From: Martyn White <Martyn.White@arun.gov.uk>
Sent: 22 June 2020 17:16
To: Planning.Responses <Planning.Responses@arun.gov.uk>
Subject: P/41/20/DOC

P/41/20/DOC

Approval of details reserved by condition imposed under ref P111/19/PL relating to Condition Nos 3 - details of Cedral cladding and 4 - details of how adjacent curtilage listed wall will be protected (method statement).

Proposed Ground Floor Plan.
(Showing Foundation Works)
(1:50)

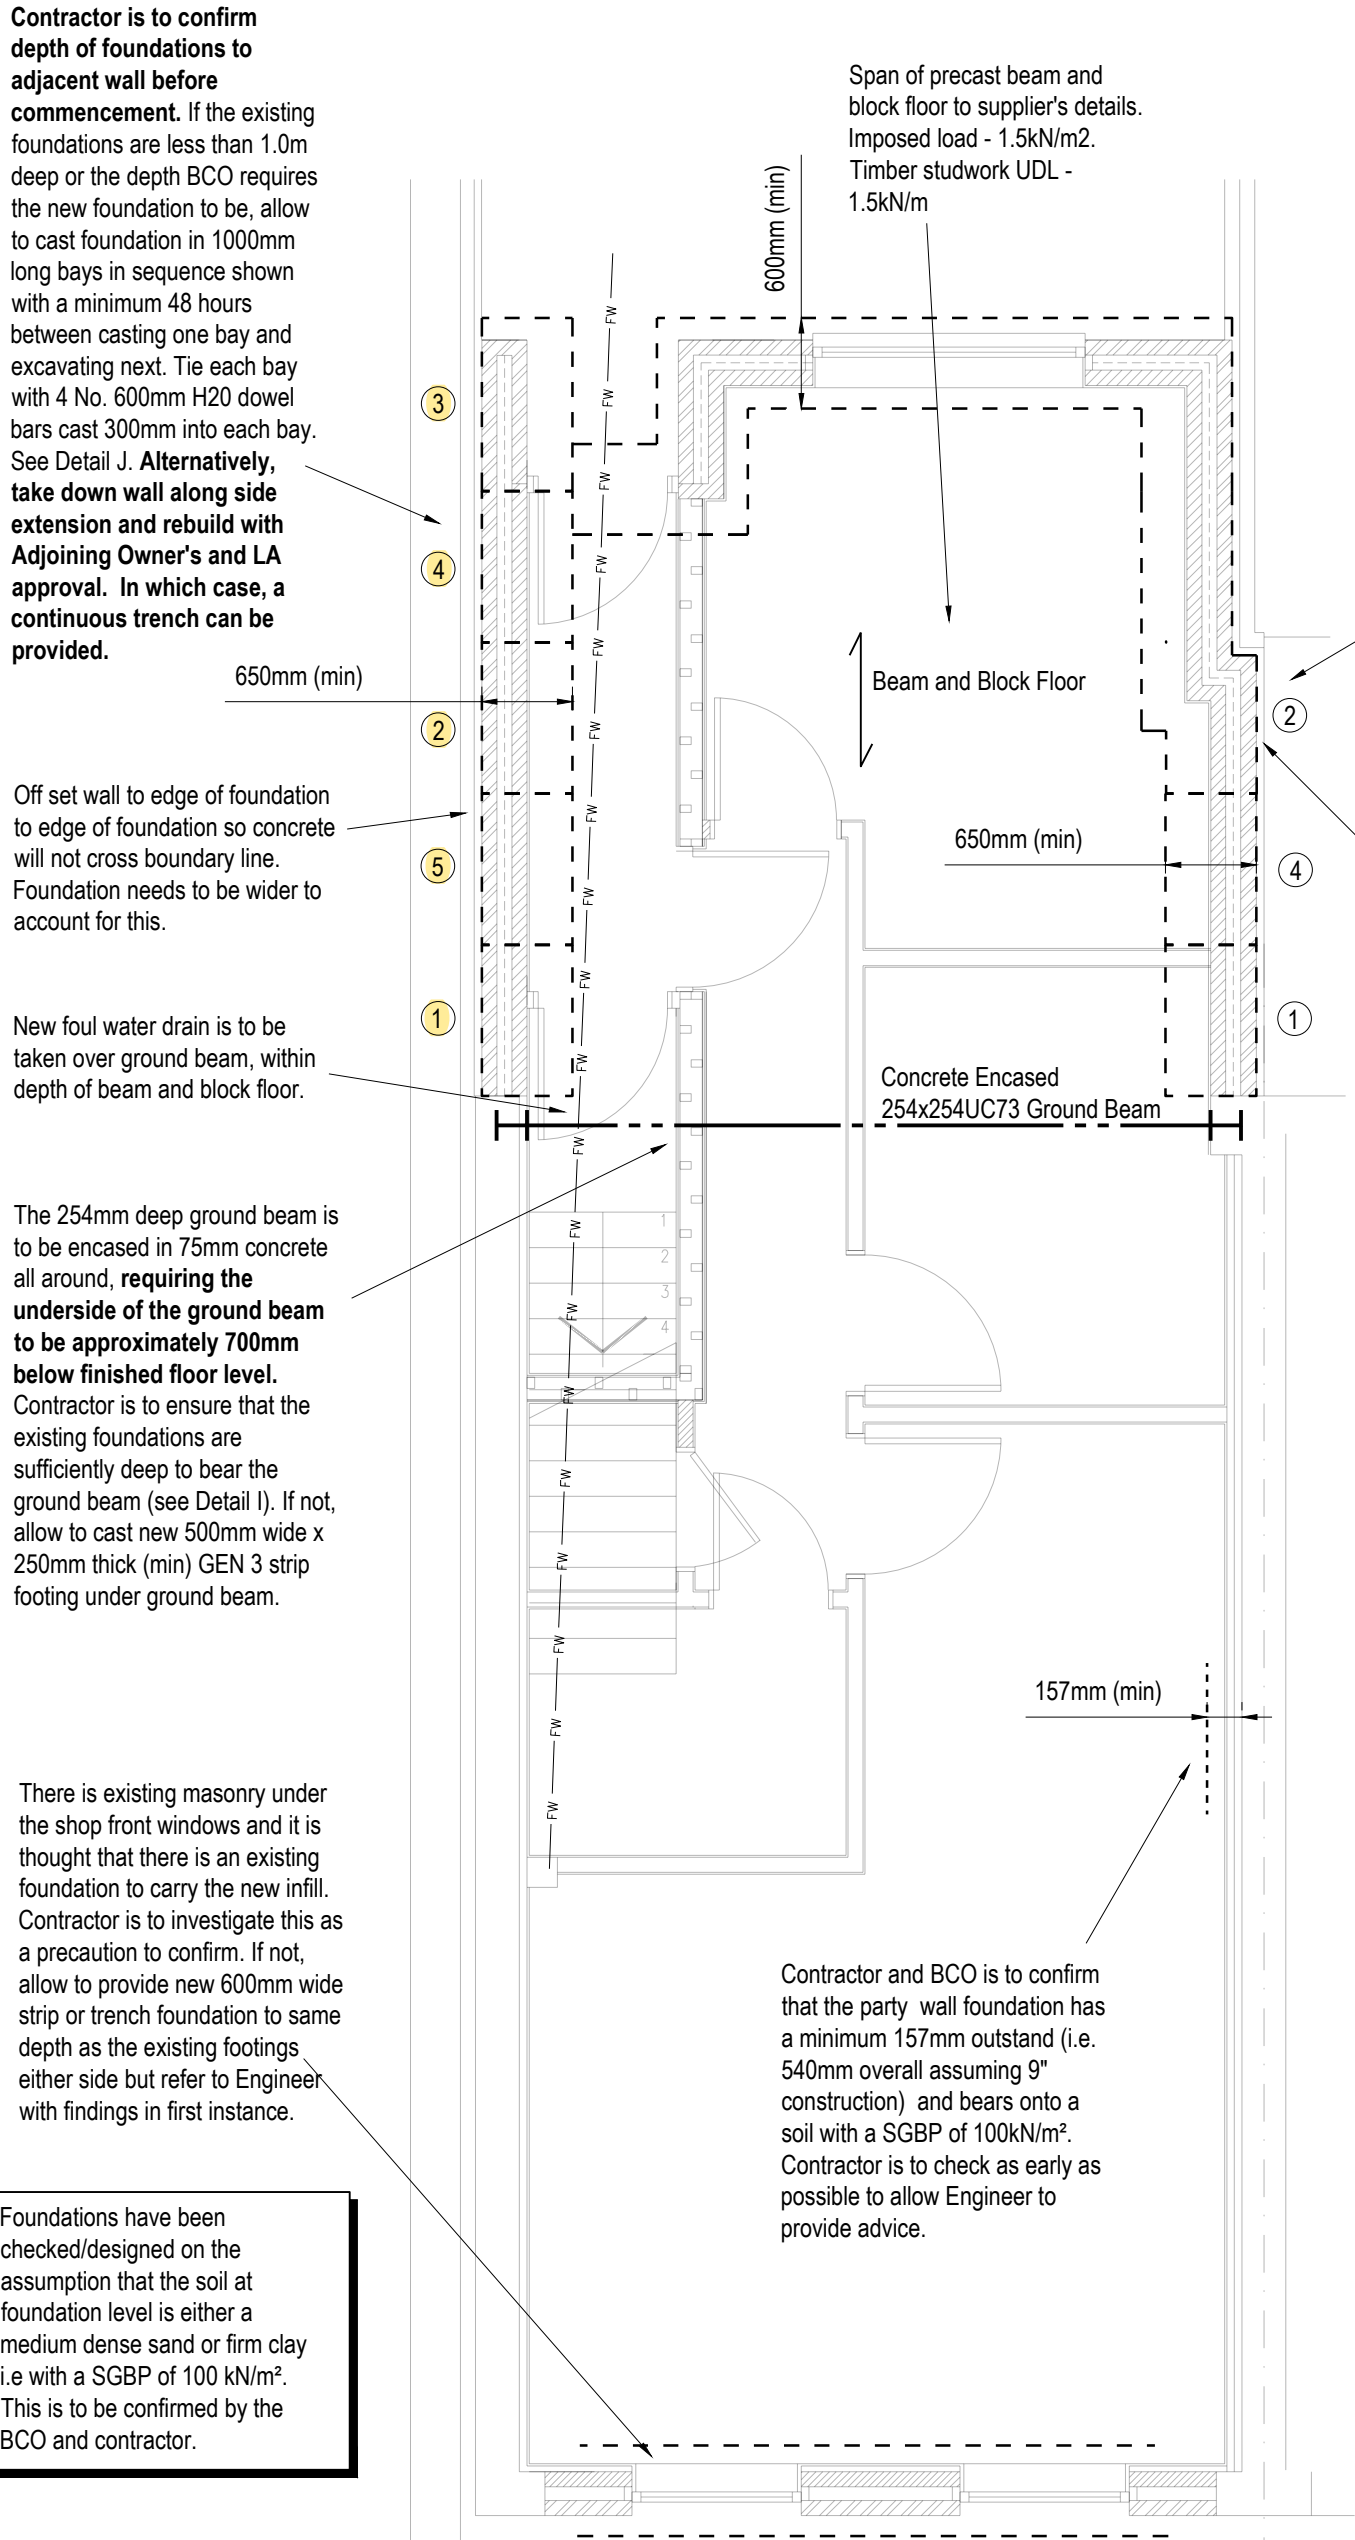
I note that reference is made to the potential removal of part of the wall. Any works which affect it, especially demolition would require listed building consent as it is a curtilage listed structure. This would require an assessment to the impact caused by the loss of the structure.
